Applicant: Natalie DiBenedetto

Address: 722 Congress St

permit # 2014-01574

CHECK-LIST AGAINST ZONING ORDINANCE

### PERMEABLE SURFACE DIAGRAM

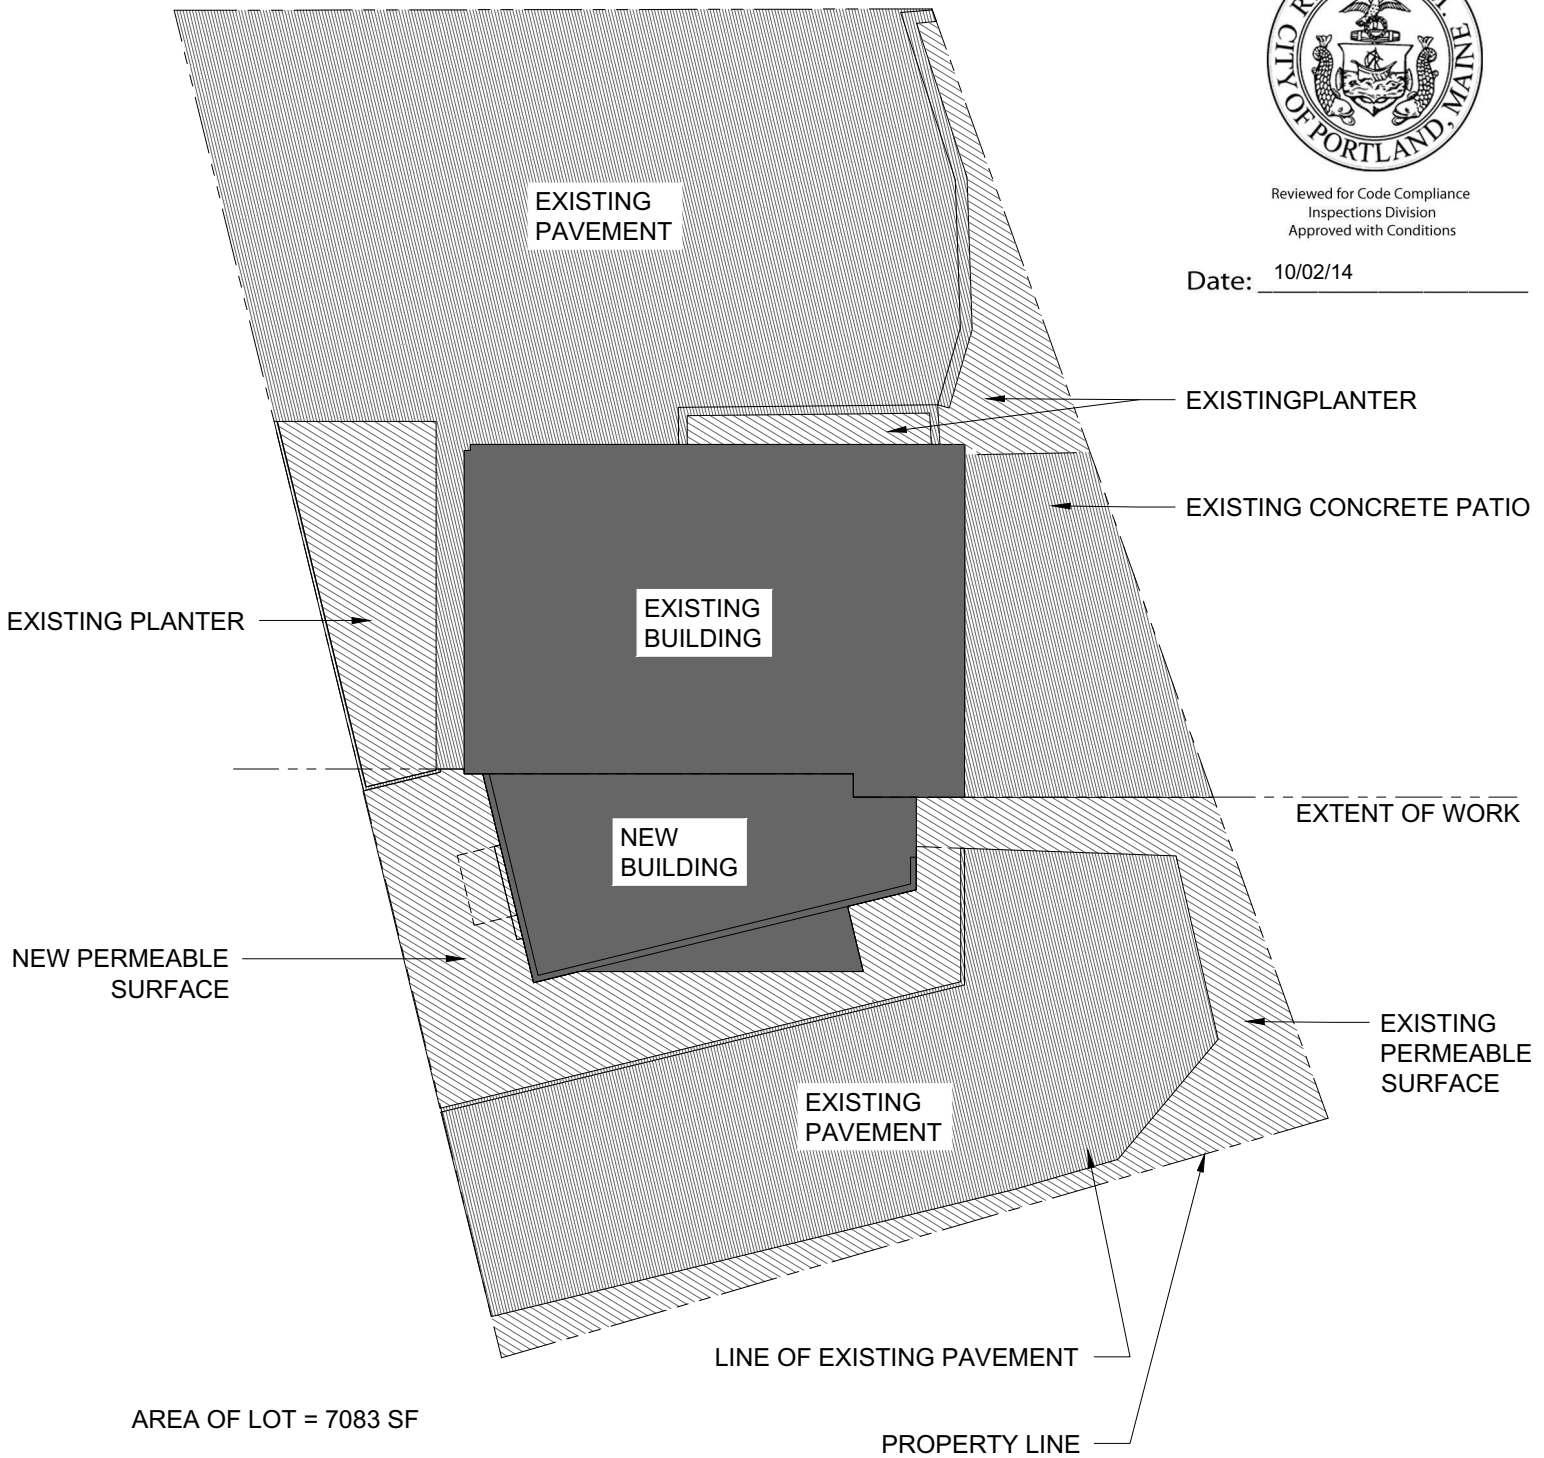
* Lot Coverage/ Impervious Surface - 90% - 87% as shown on plan SK-1
